**SSD 6626 - SICEEP Darling Square - Mixed Use Residential
Building within North-East Plot**

SSD 6626 Submission

SICEEP - SSDA7 Shadow Study

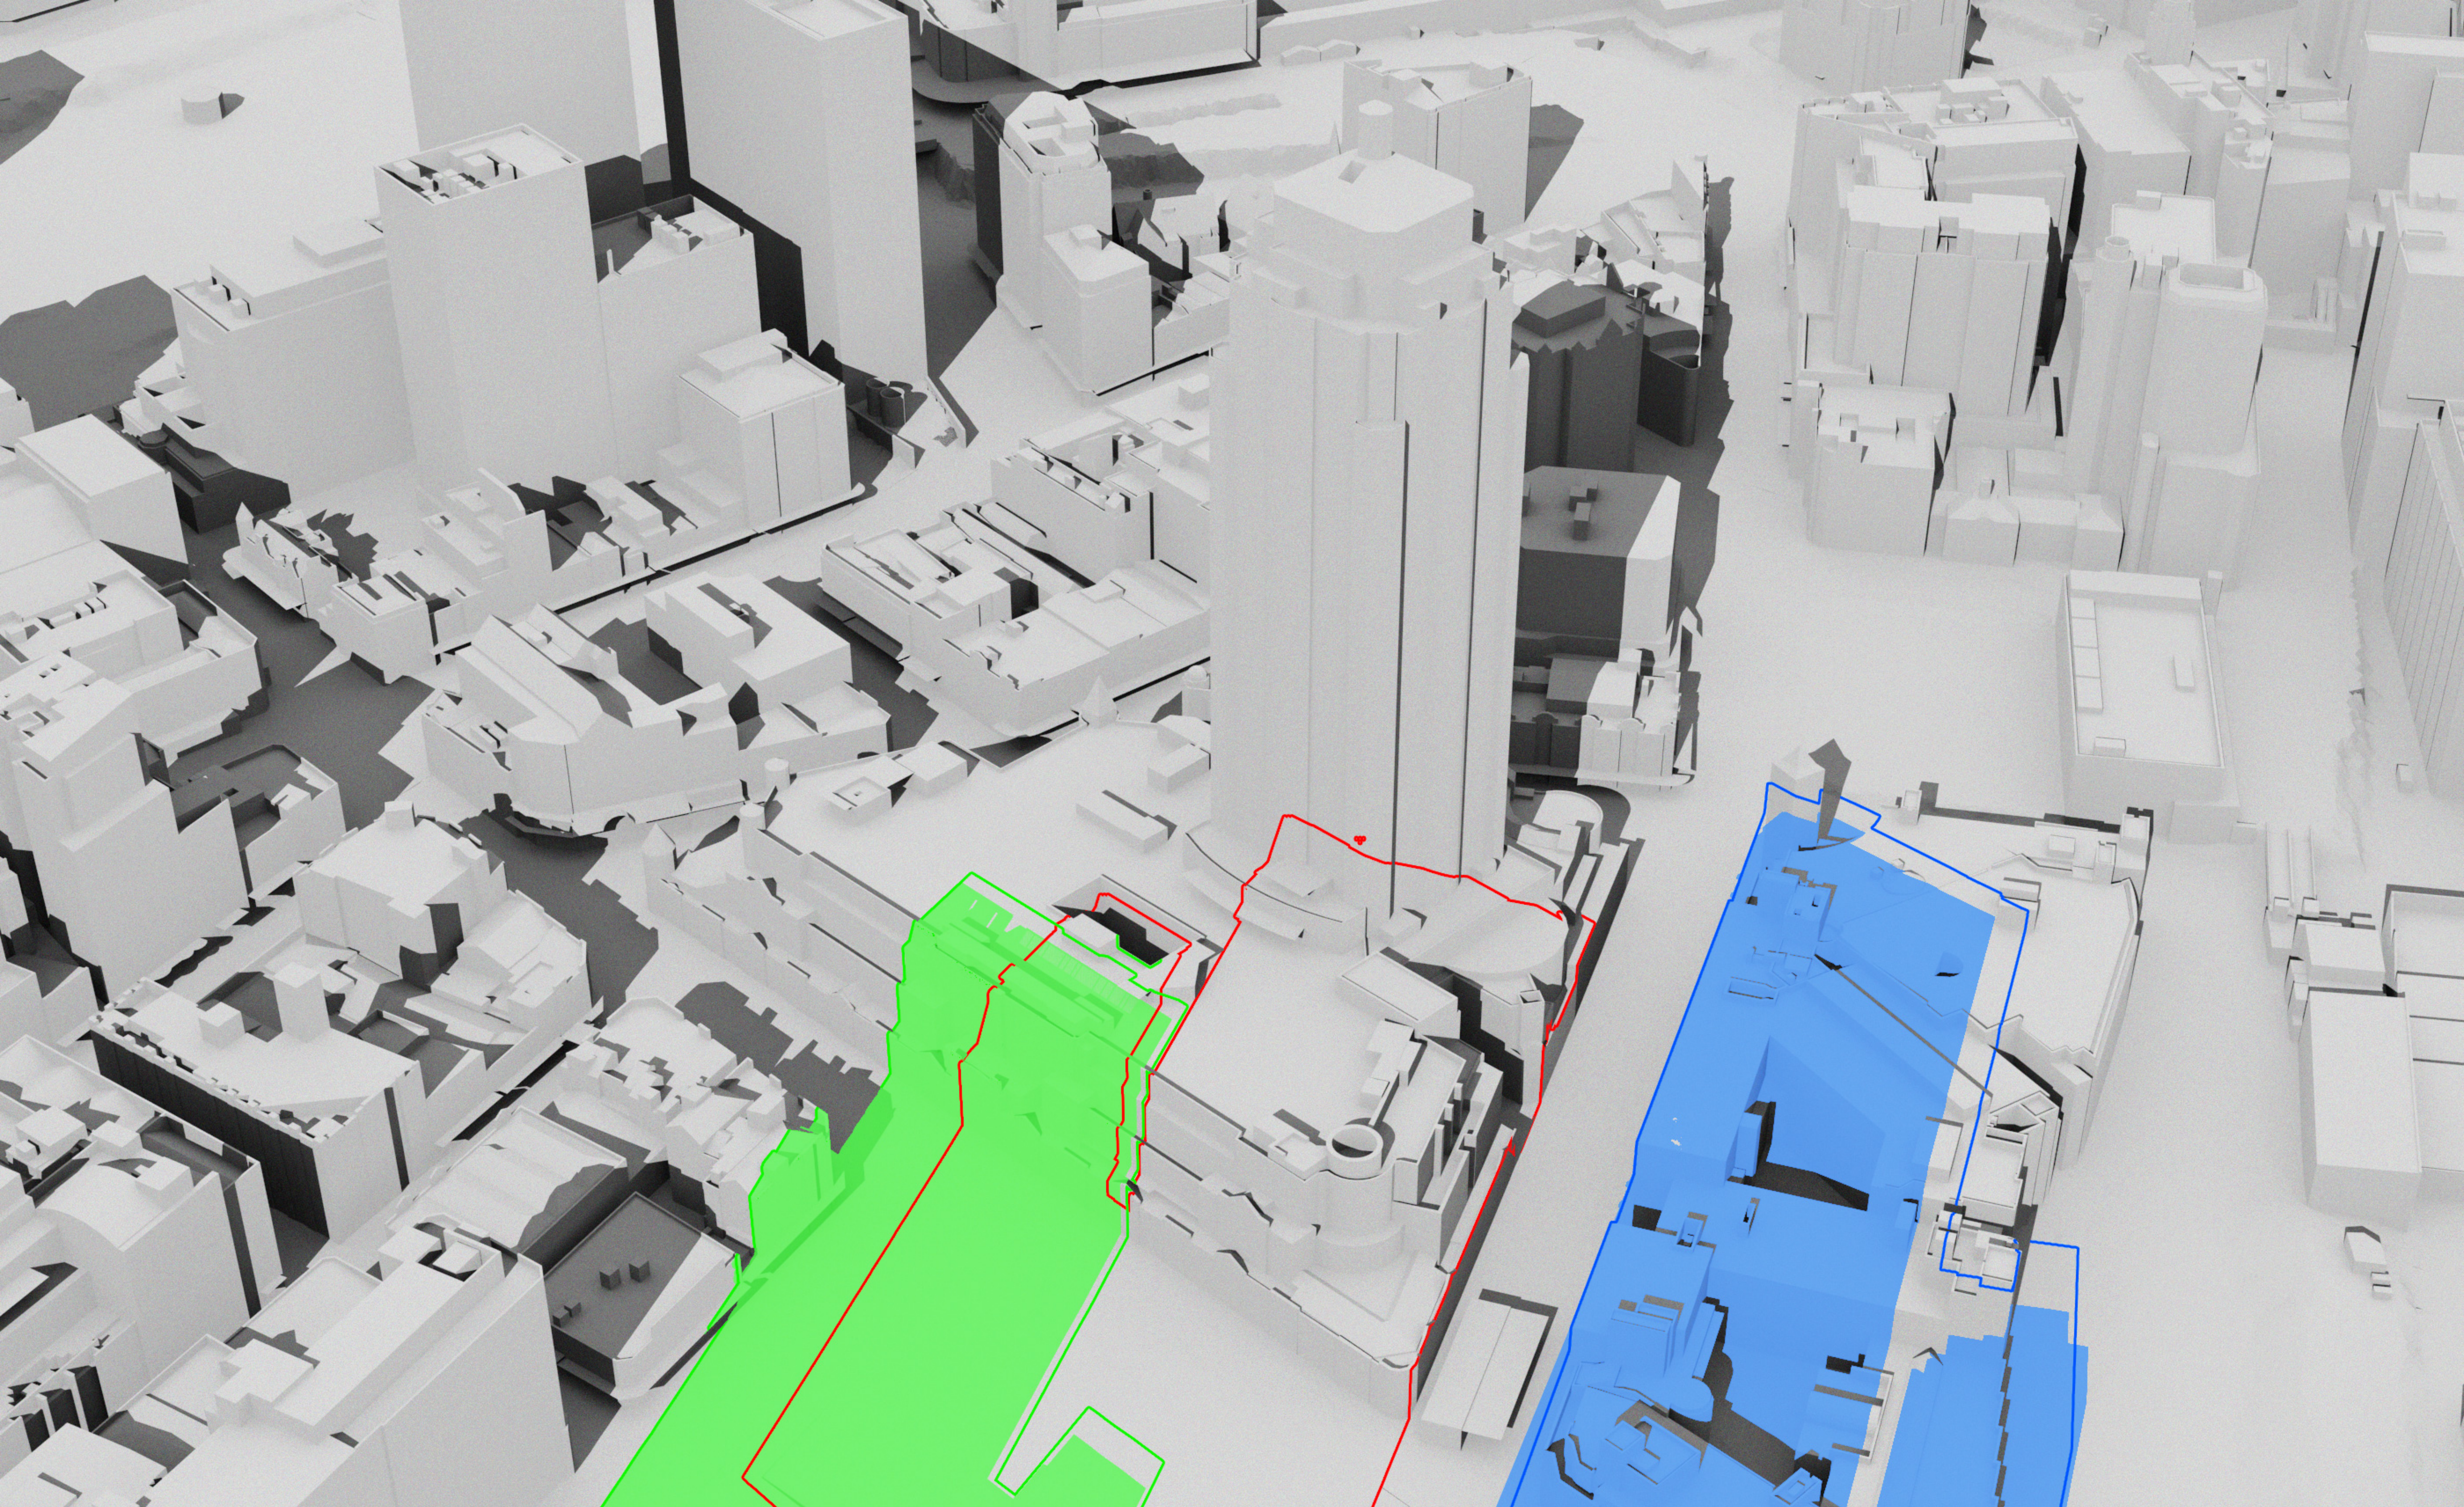
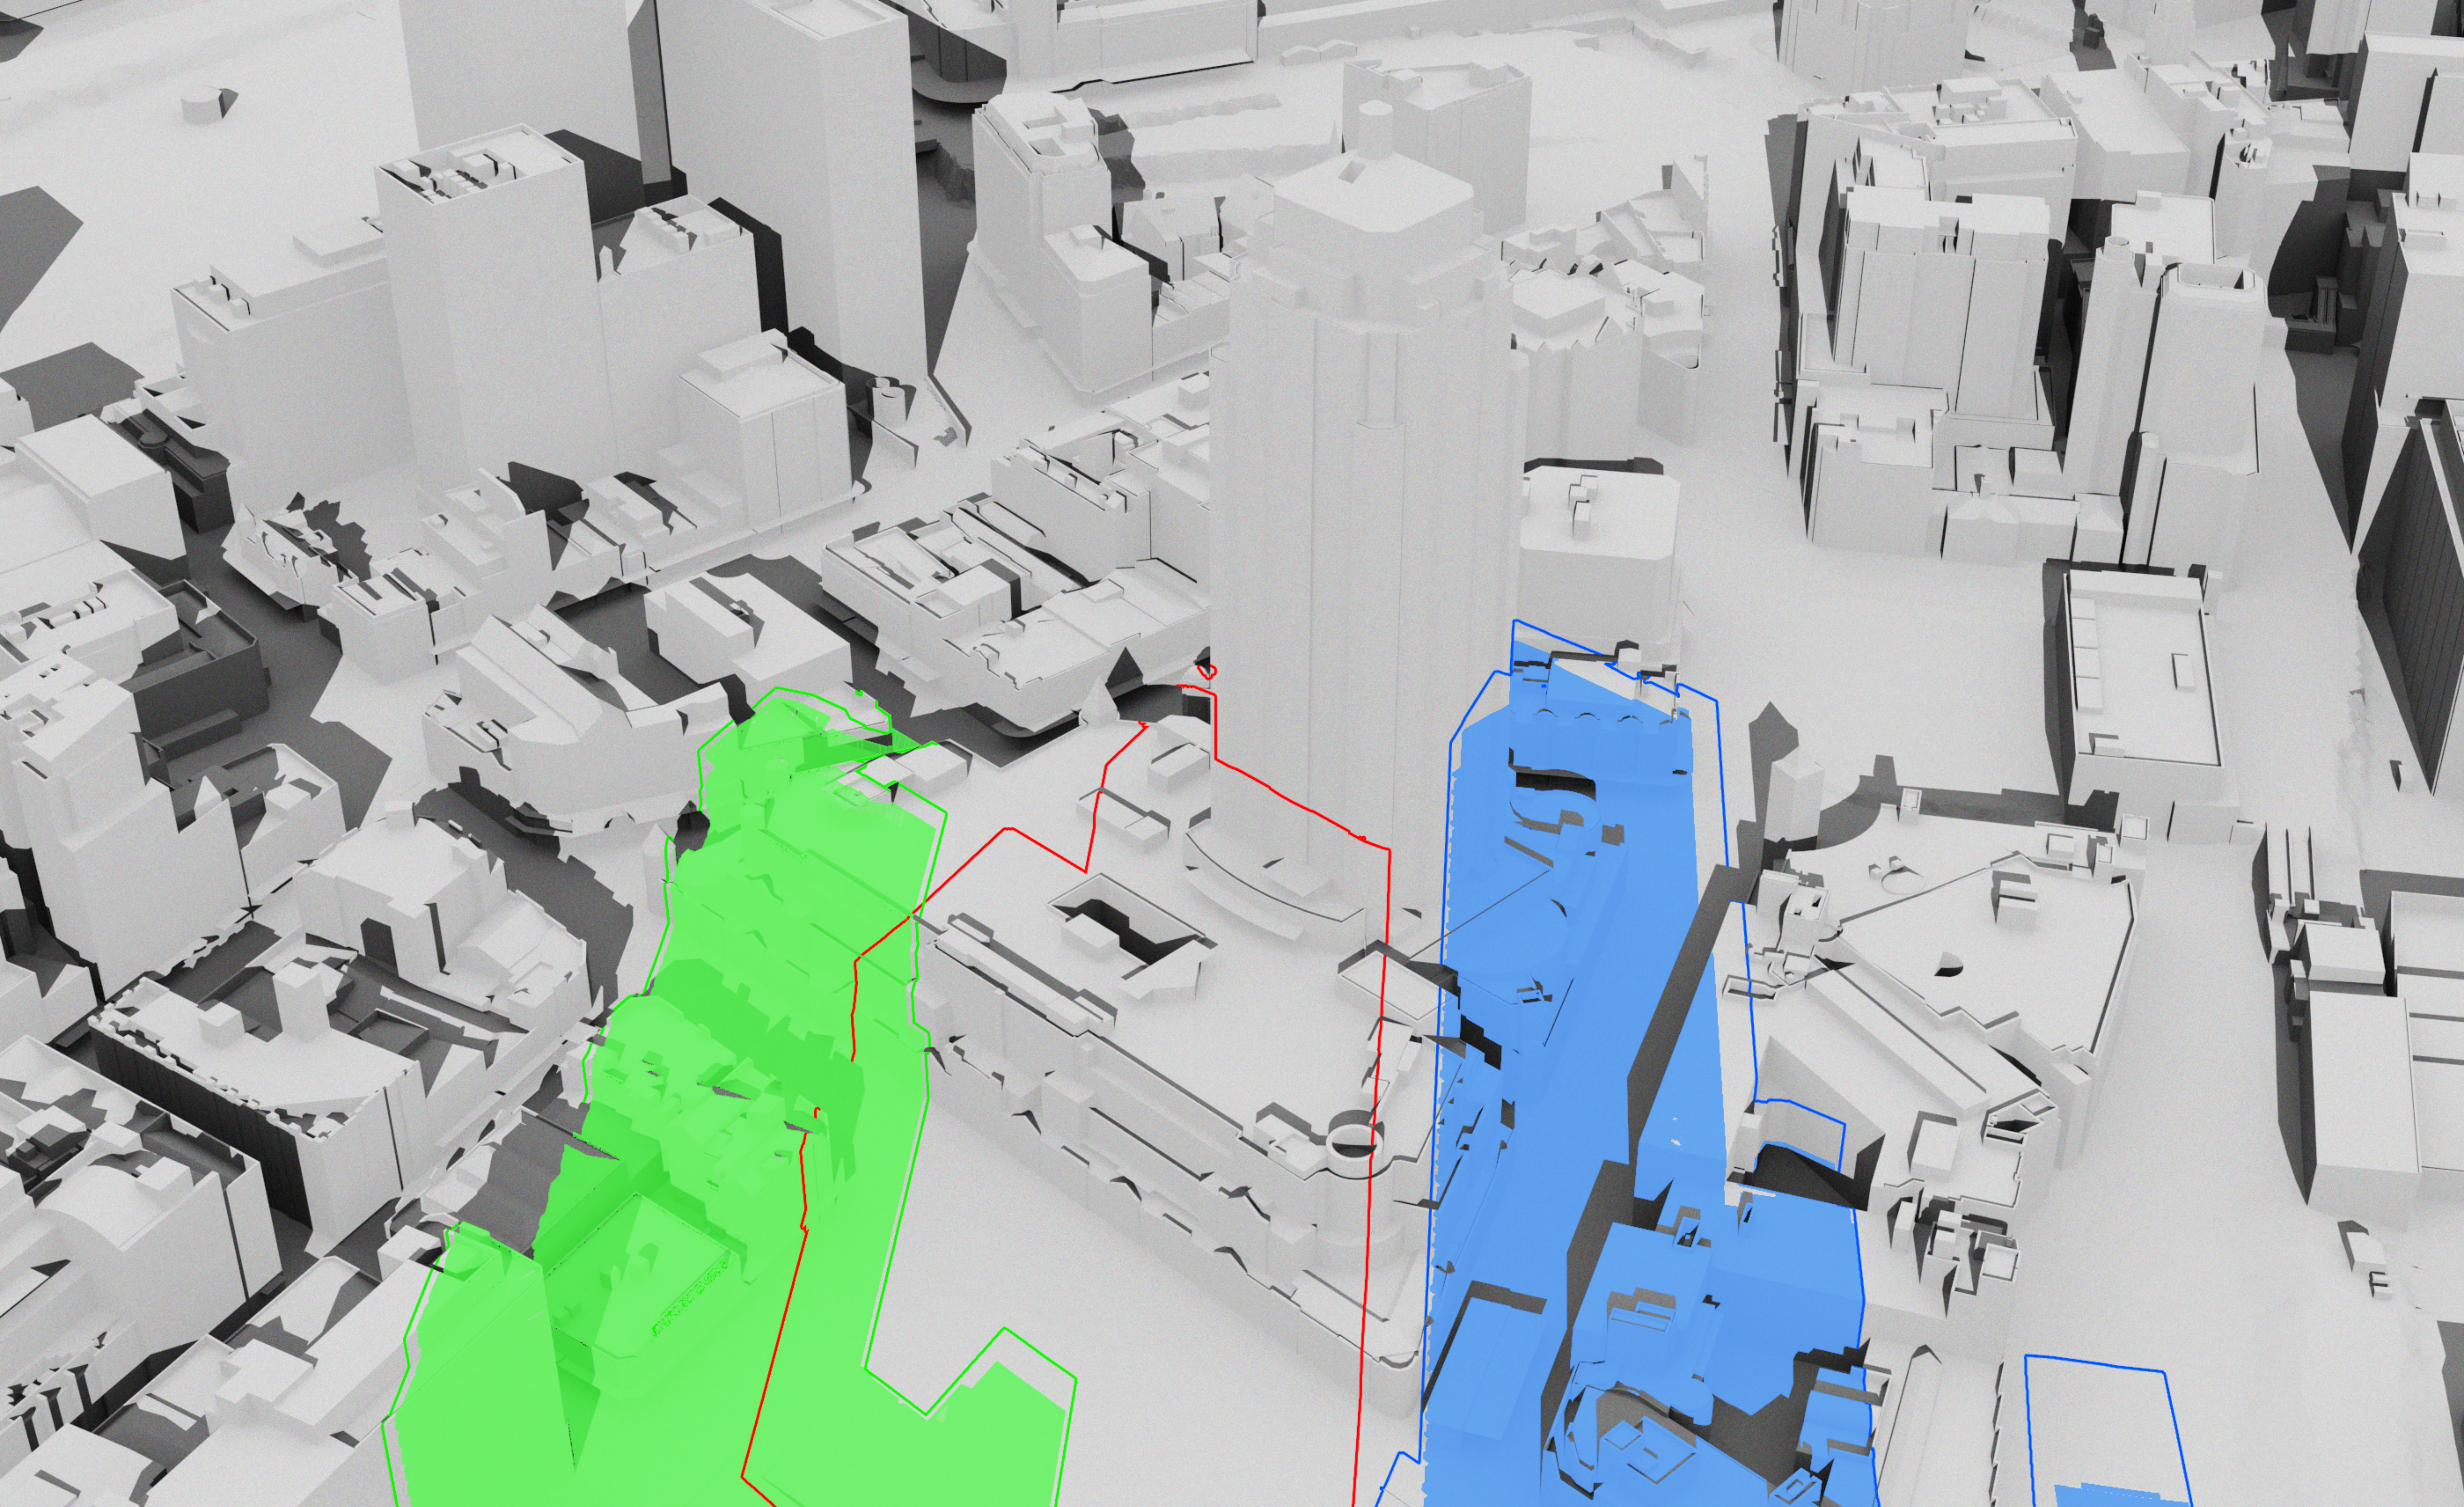
Excessive overshadowing of The Peak podium

With respect to the podium of The Peak Apartments, the EIS states that "The landscaped podium associated with The Peak Apartments will continue to receive at least two hours of solar access, ensuring compliance with the intent of the Sydney DCP 2012.". Although this statement is true, two hours is a major reduction from the existing 21 June daylight access of about six hours.

Excessive overshadowing of The Peak apartments

There is no overshadowing of apartments in The Peak by the NE plot. The overshadowing is by the SW plot being developed by the same proponent.

We take this opportunity to reiterate our submission on SSD 6011 (SW Plot) which stated "It can be concluded that, as a result of combination of the proposed (SW) development with existing shadowing of the west façade, some single aspect apartments on the west façade and the south-west dual aspect corner apartments which currently receive less than 2 hours direct sunlight to habitable rooms and 50% of the private open space between 9am and 3pm on 21 June will suffer additional overshadowing. " At the time of designing the development, the proponent was, despite having made numerous site visits, unaware that there were single aspect apartments in the Peak. The proponent now belatedly accepts that there are 110 apartments in the Peak which are single aspect west or north. The proponent's response to not meeting DCP overshadowing standards for those apartments was "The Sydney DCP does not apply to the SICEEP site." (SSD6011 South West Plot SSDA5, Response to Public Submissions, p2). Presumably the proponent will make the same response on any point where its standards fall below those of the Sydney DCP. And the consent authority is apparently not concerned by adopting standards below those of the Sydney DCP.

Excessive overshadowing of public open space - the new square - "Haymarket Square"

We agree with the City of Sydney's view that "excessive morning shadows are cast into the outdoor and café areas in the new square by new surrounding building edges. In order to improve morning sun access to the square in winter, it is recommended that the building heights lining the new square be reduced and the floor area relocated to the surrounding streets podium edges..." Source: City of Sydney, SSD 5878 (SICEEP) The Haymarket submission, page 34.
